**Recommendation Report for Listed Building Consent for Alterations, Extension or Demolition of a
Listed Building**

REF NO: A/7/26/L

LOCATION: Elm Grove Cottage
The Square
Angmering
BN16 4EA

PROPOSAL: Listed building consent for the replacement of two windows on the ground floor at the rear of the house.

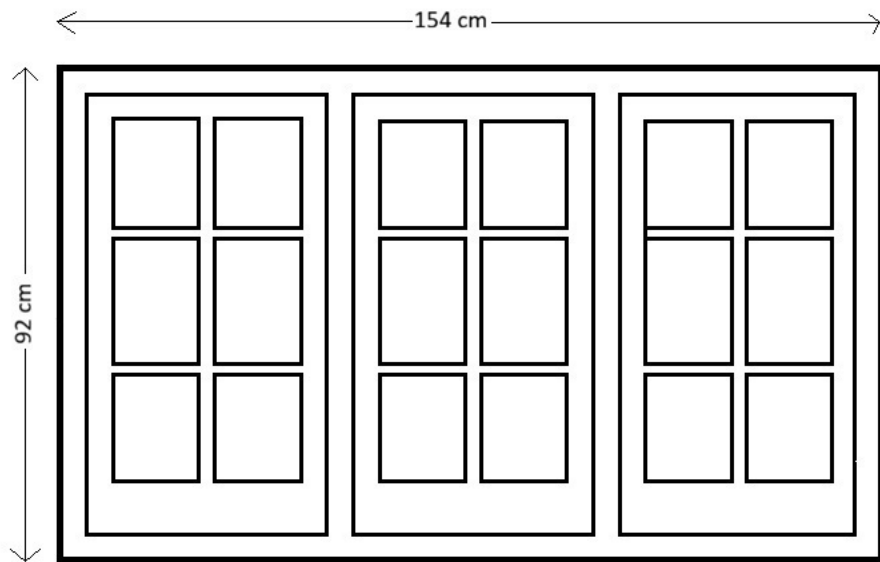
The plans appear to show flush fitting side hung casements which would match the originals but, in view of the designated heritage asset context, it is suggested that, for the avoidance of any doubt, this should be confirmed. In addition, it should be confirmed that the glazing bars are to be properly formed, and not false.

The existing windows do not appear to be of historic significance, and there is potential to replace them with windows incorporating heritage-style double glazing. However, the level of information submitted is minimal, making it difficult to assess the proposal's full impact. There is no detail regarding the glazing specification, specifically whether the units will be standard 28 mm or a slimmer heritage-type profile. As you are aware, standard 28 mm glazing units would not be acceptable.

Where windows incorporate glazing bars, these traditionally form part of the structural frame. Applied (non-structural) glazing bars are historically inaccurate and visually unconvincing. The plans do not make clear whether the proposed glazing bars are integral or applied, and this needs clarification, as applied bars would not be supported.

At present, the information provided is insufficient to assess the impact of the proposed works. Further details are required, including glazing specifications and confirmation of whether glazing bars are integral or applied.

Following comments from the Conservation Officer, amended plans have been submitted that specify the glazing unit thickness and details of the glazing bars. After further discussion with the Conservation Officer, it has been determined that there are now sufficient details to enable this application to be determined, subject to a condition which has been attached to this listed building consent requiring full window specifications to be submitted and approved in writing by the Local Planning Authority prior to installation.
